# Rezoning Transportation Analysis

Petition Number: #2022-029

General Location Identifier: 08108415

Skyline Townes
Rezoning Site Plan
 955 Seigle Avenue Charlotte, North Carolina

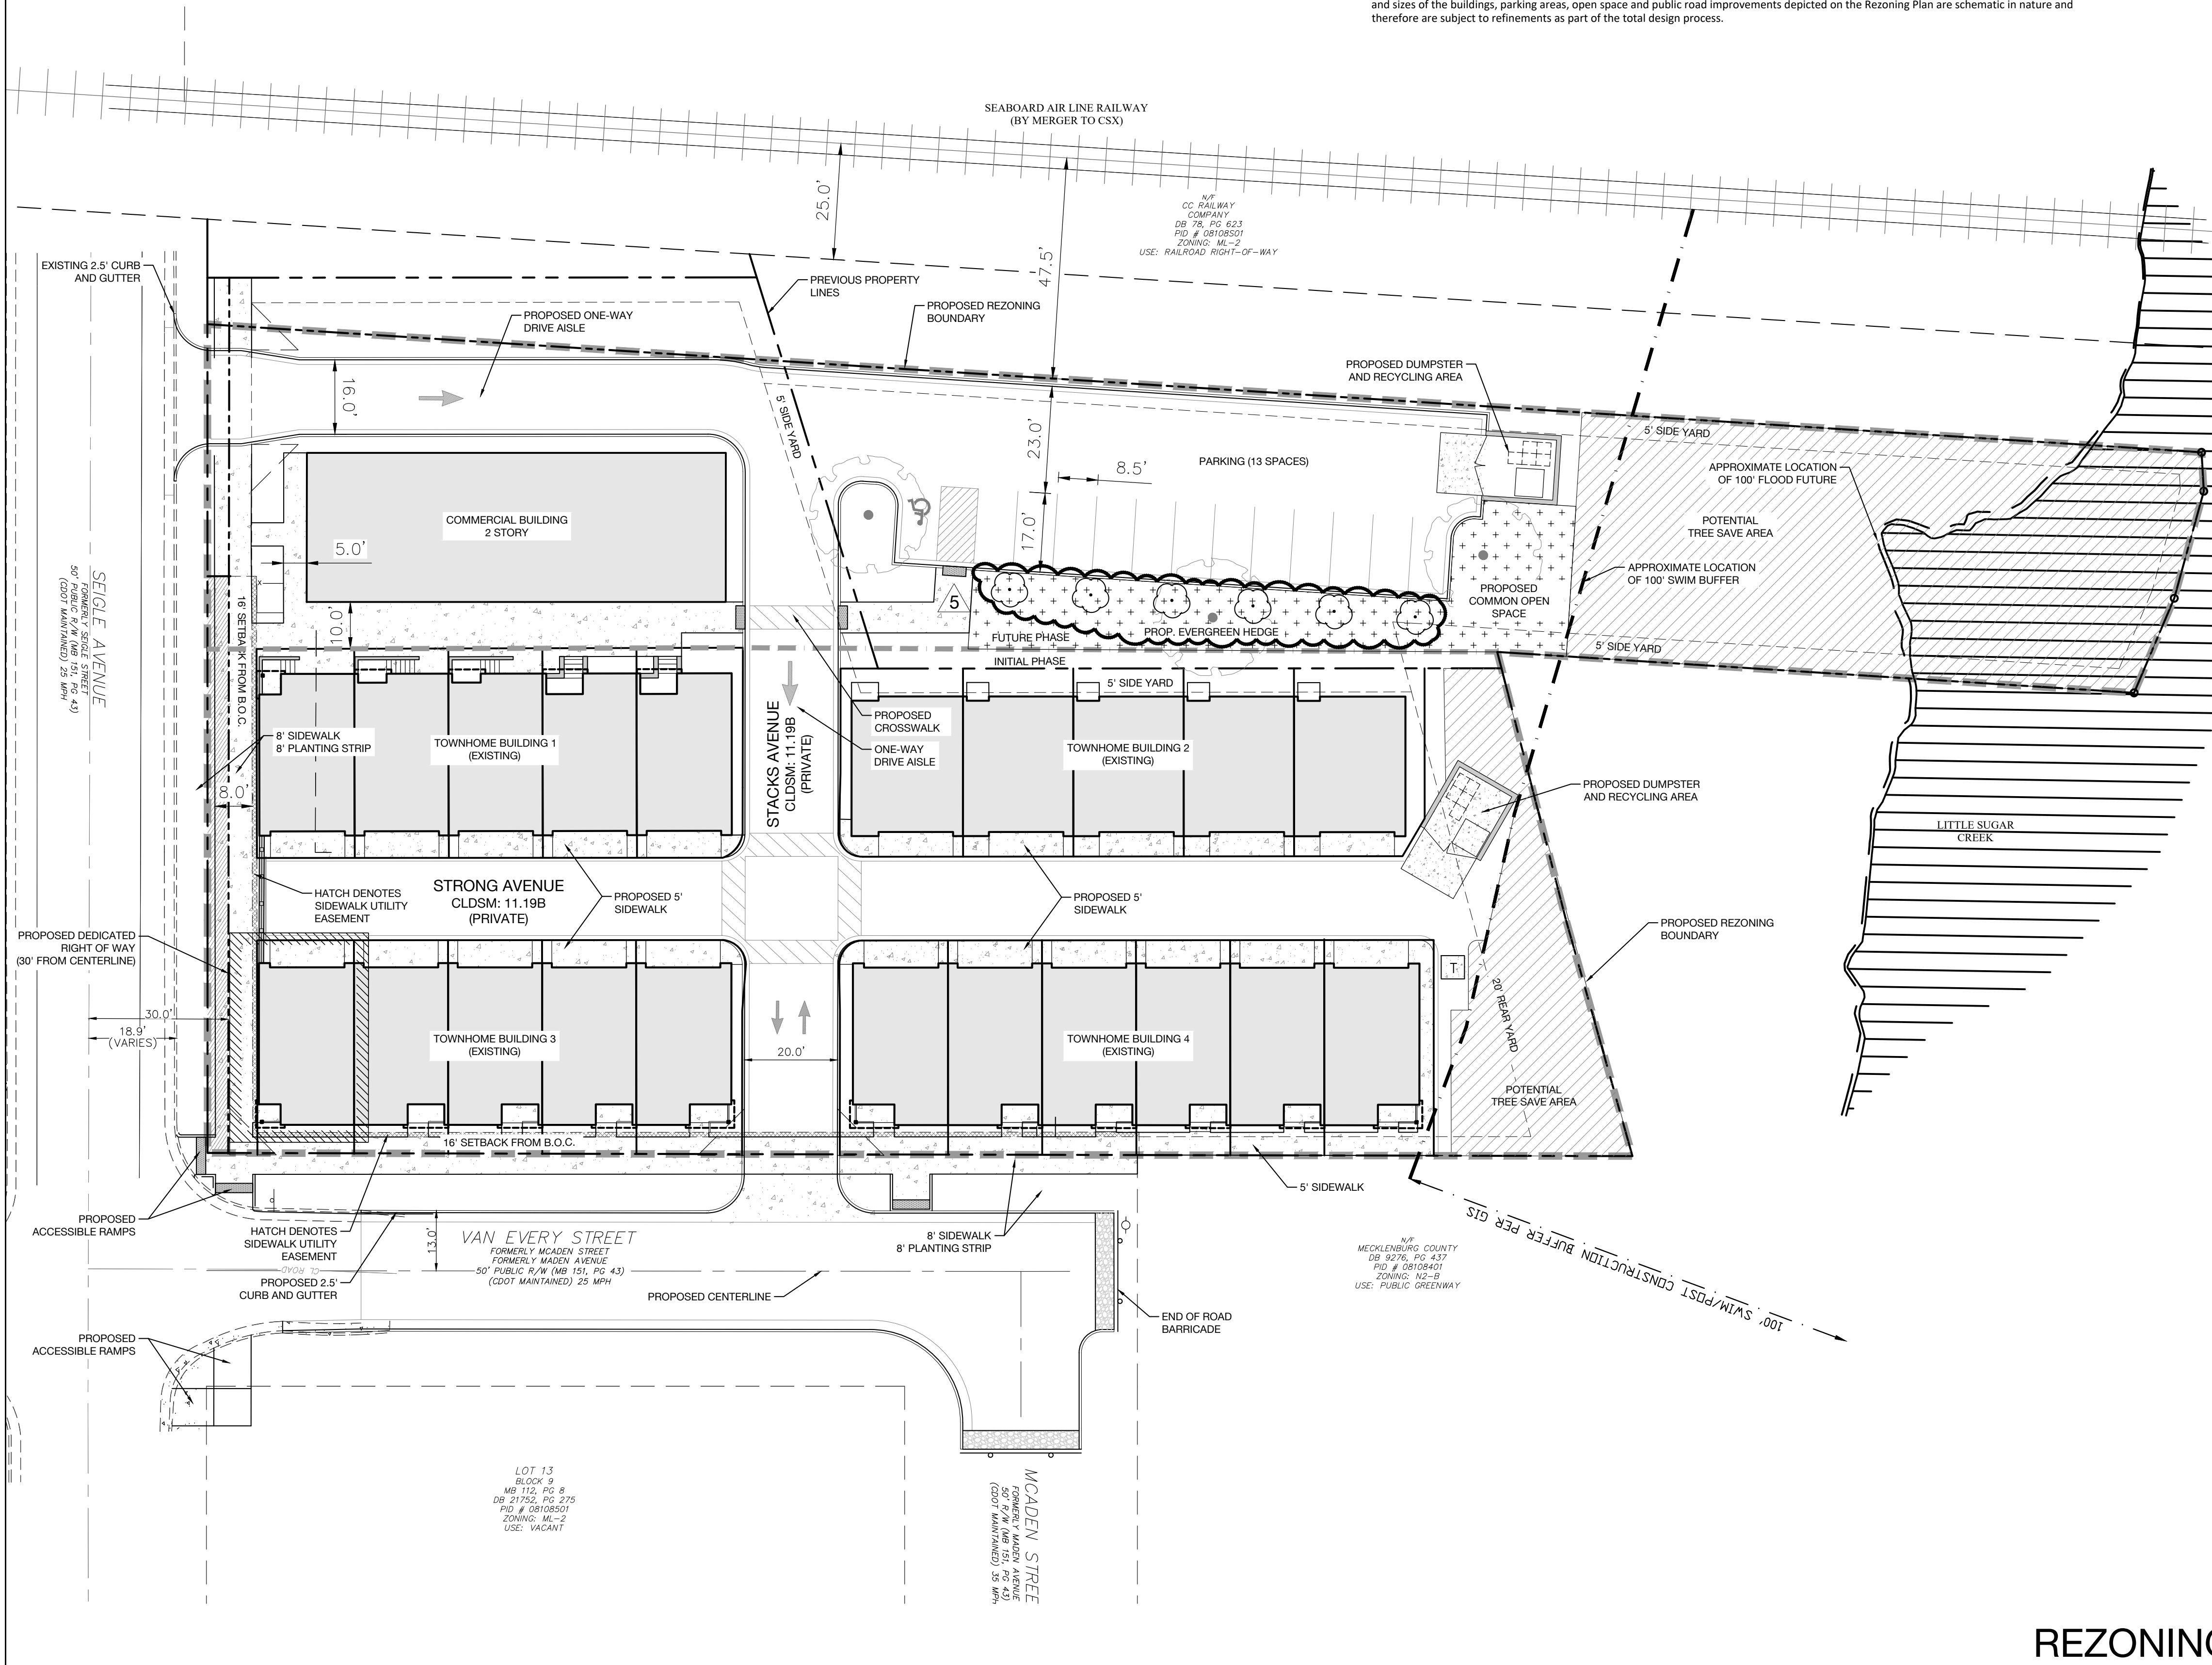
### 2. ~~Outstanding Comment from 08-23-2022~~ Revise site plan and conditional note(s) to list out proposed transportation and site improvements and their proposed phases (initial, future).

- a. ~~Clarifying comment 07-25-2023:~~ Though the petition has a conditional note that all the transportation improvements will be completed by first CO, CDOT needs clarification on how the site will be phased as the entrance on Seigle Avenue is only one way.
